**Consultation Response from KC,  
Highways Development Management**

**2024/90255 Land Off, Burn Road, Birchenclyffe, Huddersfield, HD3 3BT**

**Reserved matters application, including the considerations of appearance, landscape, layout, and scale for the erection of 22 dwellings pursuant to outline permission 2019/94051 (outline application of up to 39 dwellings and associated works), discharge of conditions 27 (Arboriculture Assessment), 28 (Ecological Assessment), 29 (Public Right of Way)**

**Date Responded: 11-2-2025.**

DRAWING TITLE
VEHICLE TRACKING DRAWING

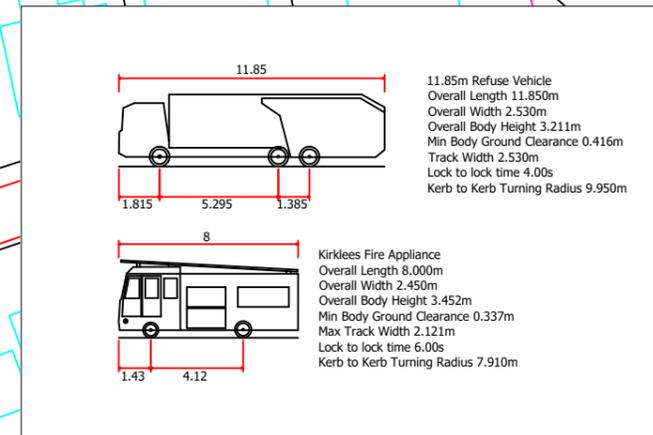
- 1, The plans should be amended to provide a 2.0m footway to all section of the proposed traditional estate road including the turning head and to the front of plots 1 to 10.*
- 2, Swept paths should be provided which demonstrate that an 11.85m refuse vehicle can enter and exit the site from Burn Road and turn within the site. All schemes must incorporate reasonable tolerances and safety margins. A good starting point is to allow 0.5m clearance to kerbing or vertical obstructions on each side of the swept path. Designs should therefore, where possible, aim to cater for vehicles larger than the above minimum standards.*
- 3, Bin collection points should be provided to all dwellings to enable bins to be presented on collection day without either obstructing the highway or proposed driveways.*
